**Re: Further Development Application for Ummerra Gravel Pit
Ummerra County Cork
For Drimoleague Concrete Works Limited
ABP Case Number: ABP-308194-20**

On behalf of Drimoleague Concrete Works Ltd (DCWL), please find attached its response to Cork County Council's submission on the Further Development application for Ummerra Gravel Pit. This response addresses the further information sought by the Council and the Council's suggested planning conditions. It is noted that the 10-page Council submission provided to me does not have any assessment reports and appears to rely on the reports relating to the Substitute Consent application. It is noted that there is some cross over in the internal Council's reports between the Substitute Consent and Section 37L Further Development applications. We have provided a response to the Council's submission on the Substitute Consent application under separate cover.

Drawing No.8

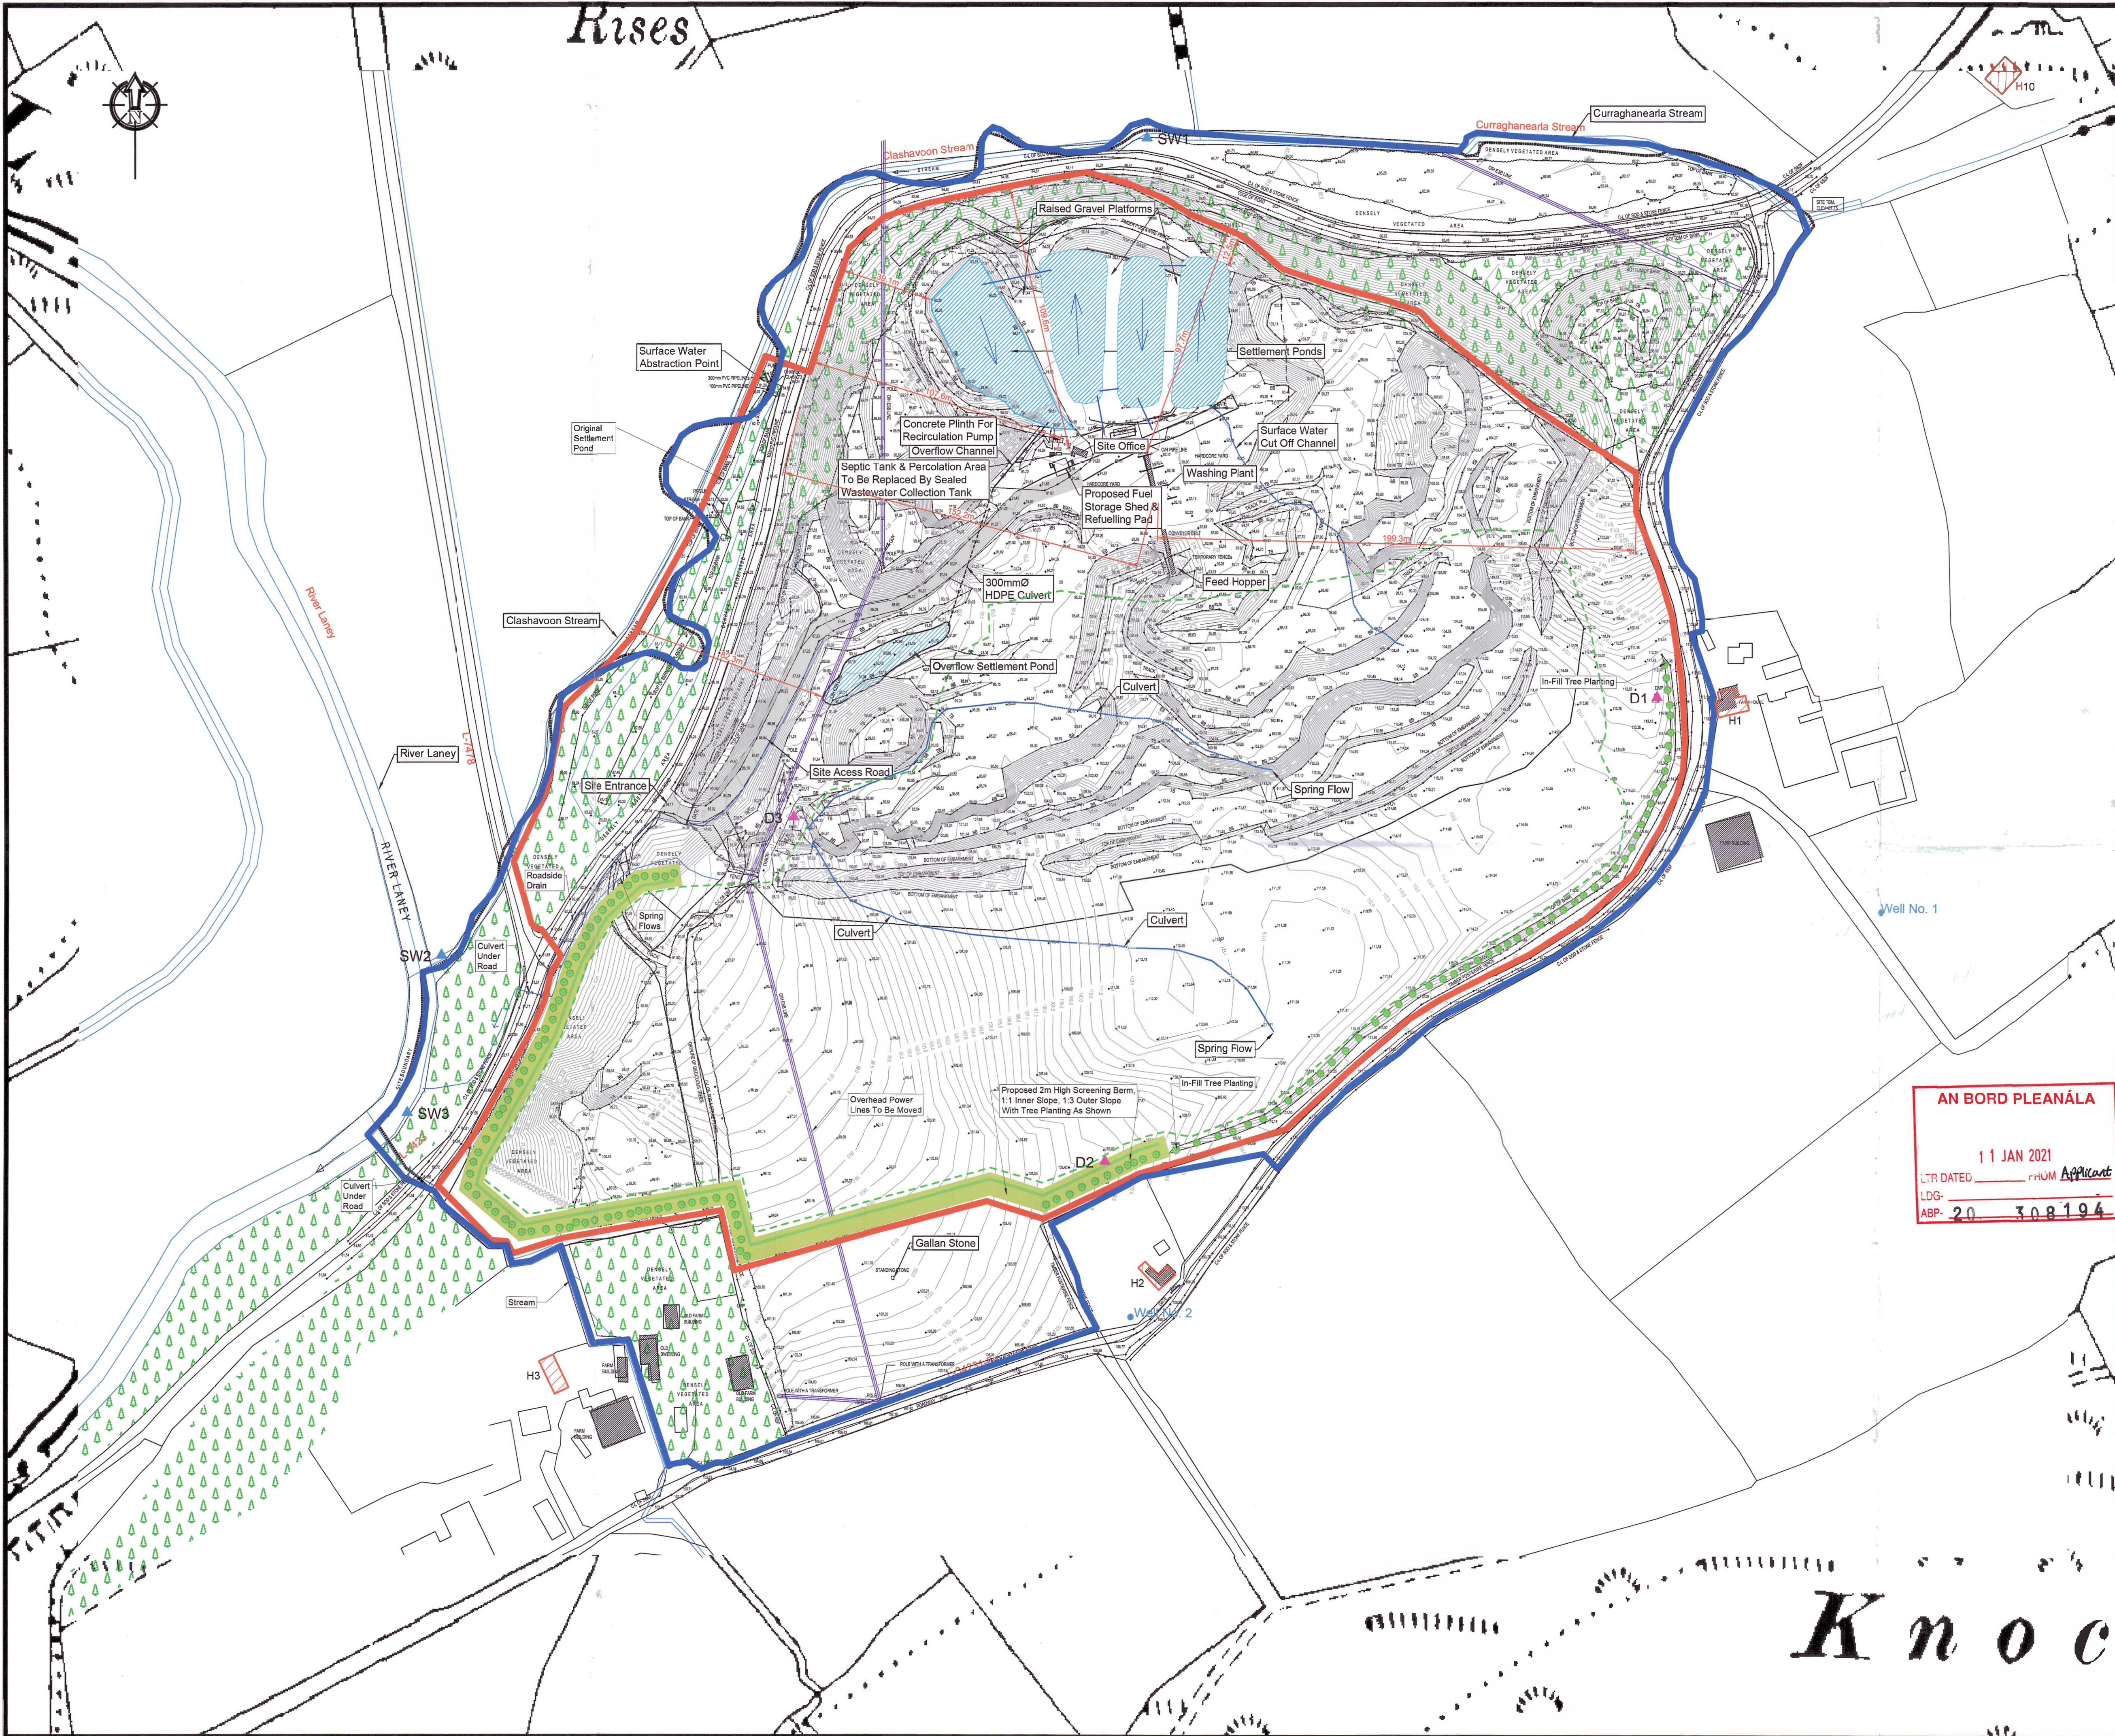
1. Map of Dust Sensitive Receptors

2. Dust Monitoring

10. Future Extraction Areas

16. Surface Water Discharges

House locations within 500m of the DCWL landownership boundary are shown on Figure 2-1 of the EIAR. The dust monitoring locations are shown on Figure 6-1. The nearest houses to the gravel pit are H1, H2, H3 and H10. Houses H1 and H2 are considered the dust sensitive locations. These houses along with the dust monitoring locations D1, D2 and D3 are shown on Drawing No. 008 - 1:1,250 scale Monitoring Point Location Plan (6 copies attached).

The dust monitoring programme for the gravel pit was submitted to Cork County Council during the registration on the gravel pit in 2005. Three locations were submitted for agreement with the Council – these monitoring points (D1, D2 and D3) are shown on Figure 6-1 of the EIAR and Drawing No. 008 (attached). It is proposed to monitor dust levels for two 30-day periods each year between May and September. The results will be compared to the emission limit value of 350mg/m²/day (the limit set by the Council during the S261 registration. Daily rainfall data from the nearest gauging station can also be submitted. It is unclear how the Council wants the assimilative capacity of the receiving environment to be determined. It is not practical for a small-scale gravel pit, with one operator, to manage an on-site meteorological station. The dust monitoring results for the site, submitted in the EIAR, are well within the emission limit value of 350mg/m²/day, demonstrating that the measures taken have been and are effective.

The areas where extraction will occur for the further development are outlined by the green dashed line on Drawing No. 008 - 1:1,250 scale Monitoring Point Location Plan. A buffer of 40m is provided to the road near H1. A 3m buffer is provided to the perimeter screen berm, which provides a minimum 15m buffer to the edge of the public roads.

Surface water features at the gravel pit are shown on Figure 7-2. They have been added to Drawing No. 008 - 1:1,250 scale Monitoring Point Location Plan. It is noted that the locations where they cross local road L-3423-20 are Council-maintained culverts.

HYDROCARBON STORAGE SHED DETAILS

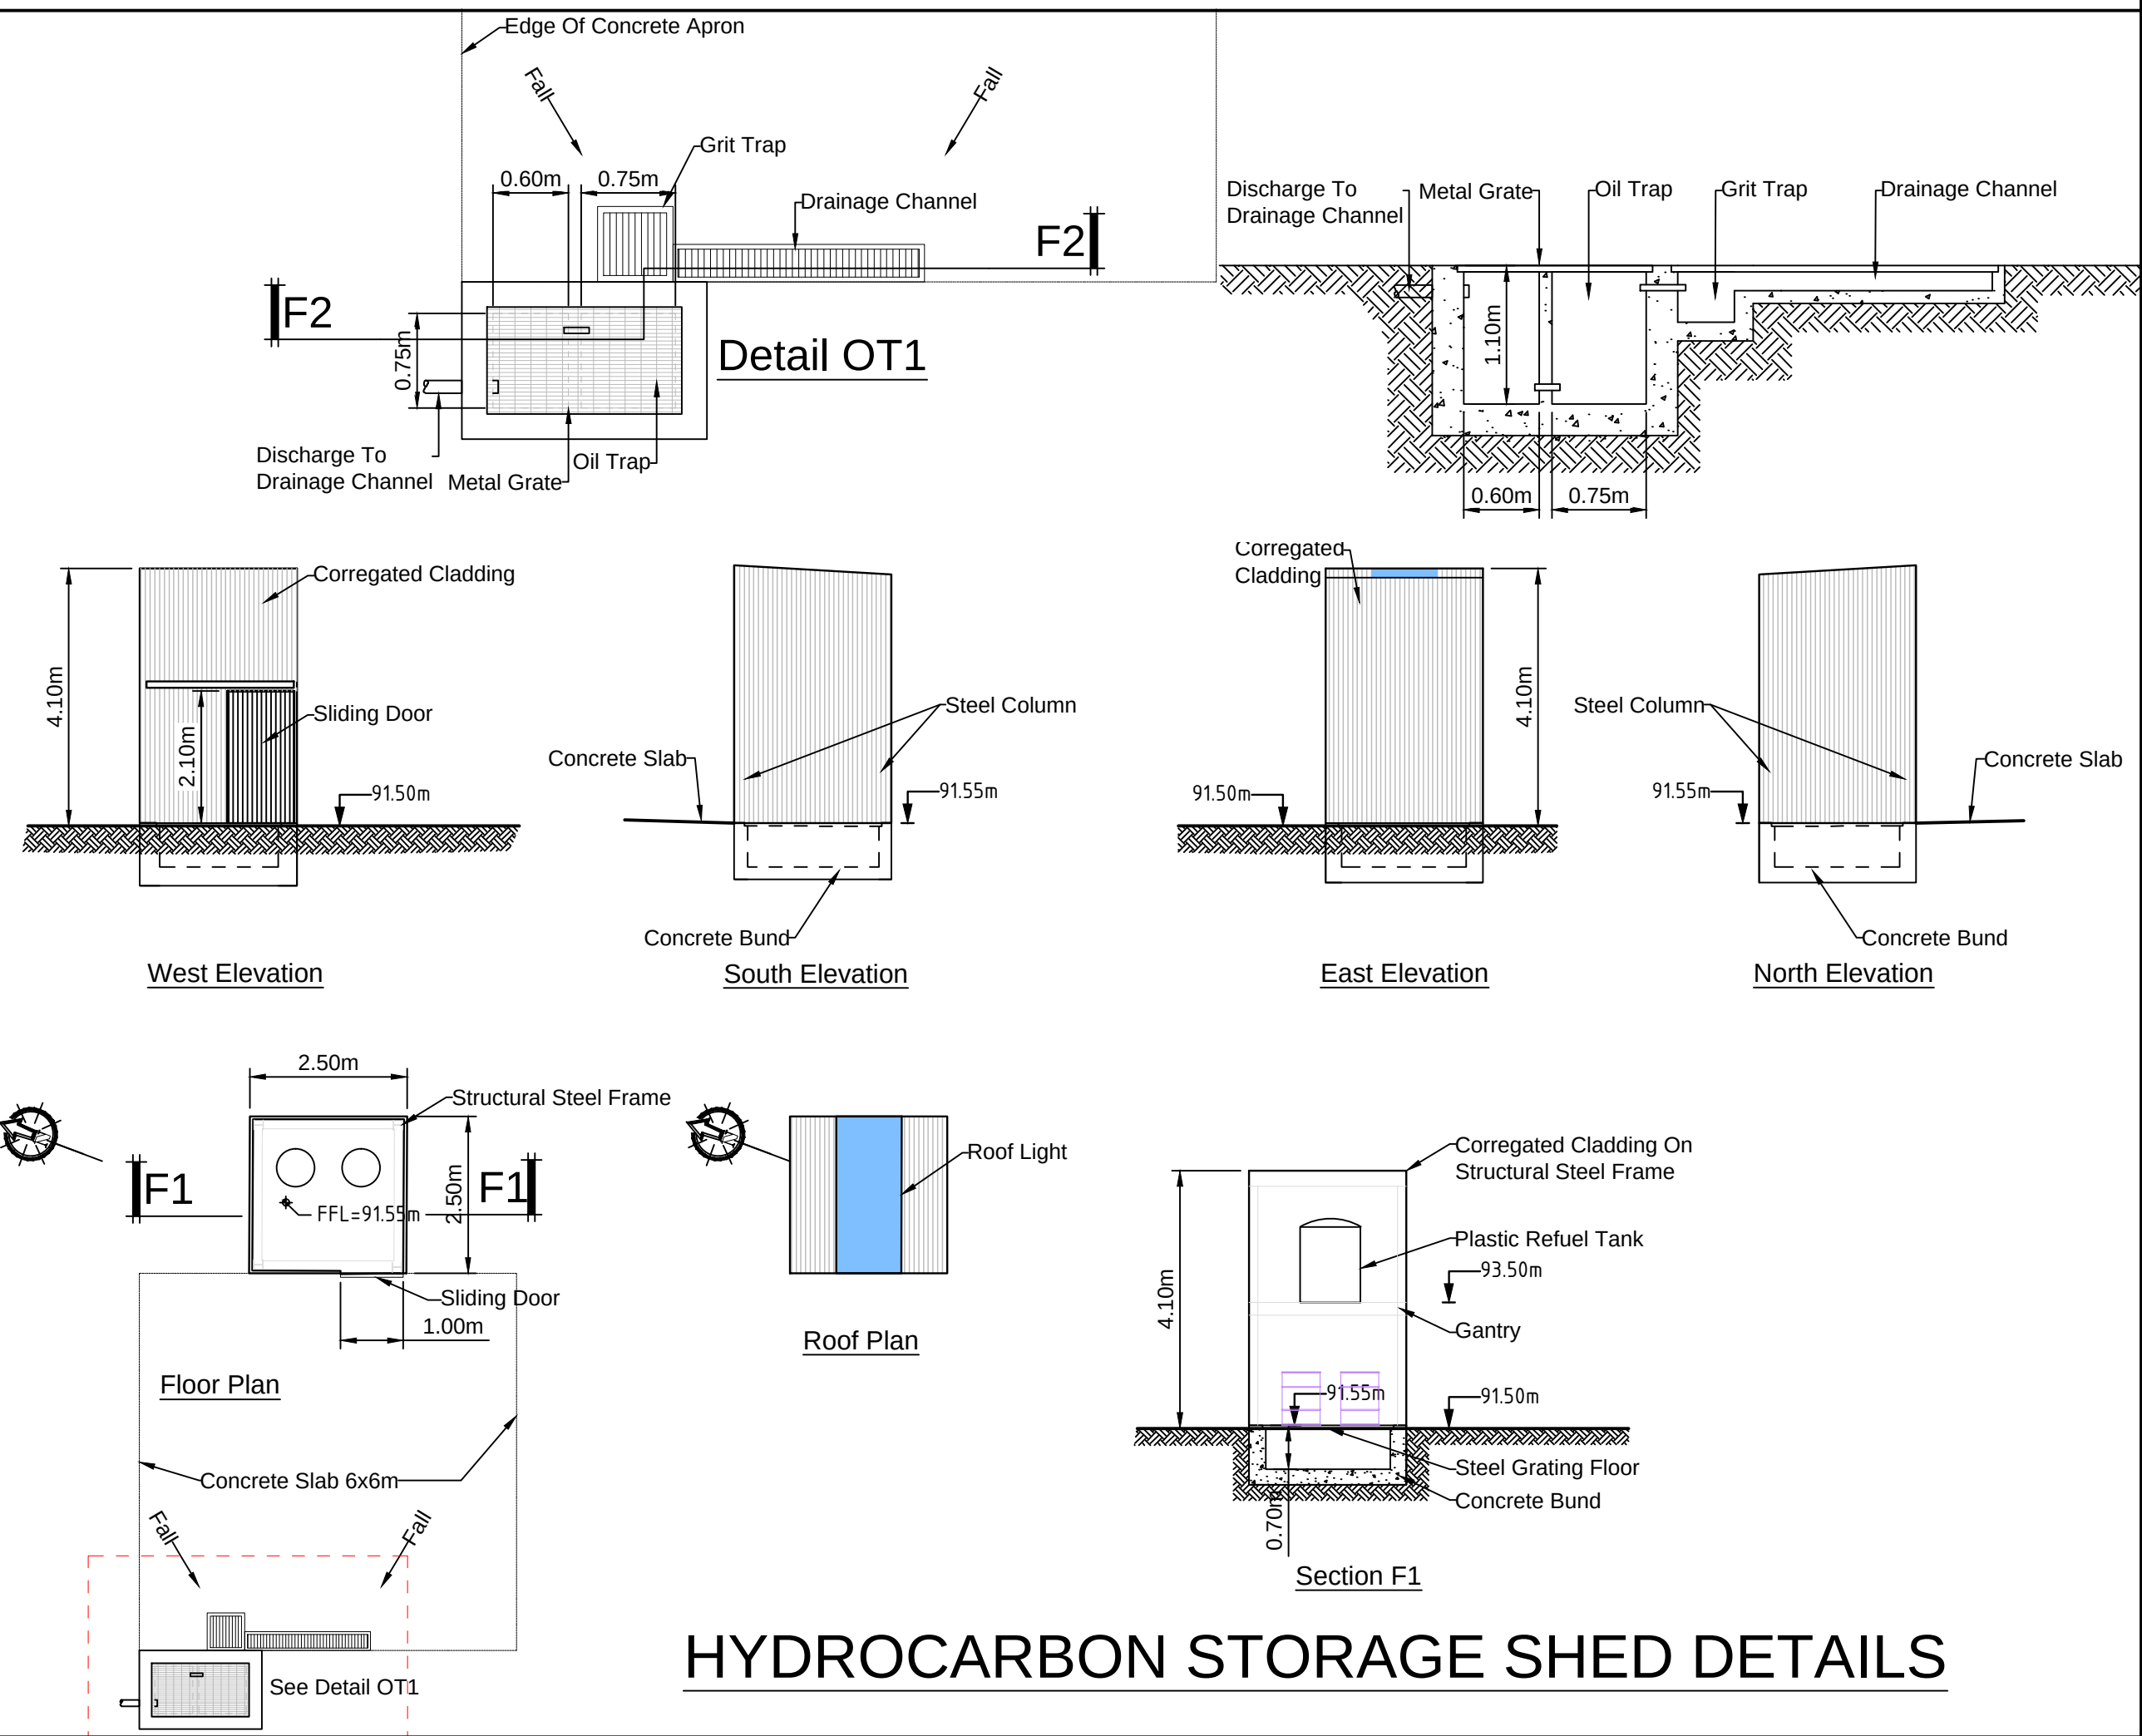
19. Hydrocarbon Interceptor

A relatively small volume of fuel will be stored and used at the site; less than a typical farmyard. The proposals to manage fuel is detailed in the EIAR and consists of the construction of a bunded fuel storage shed and concrete refuelling pad. This pad will drain to an oil trap as shown on Drawing 006. The oil trap and bund of the storage shed will be cleaned as needed, minimum annually, by a licensed contractor such as Enva.
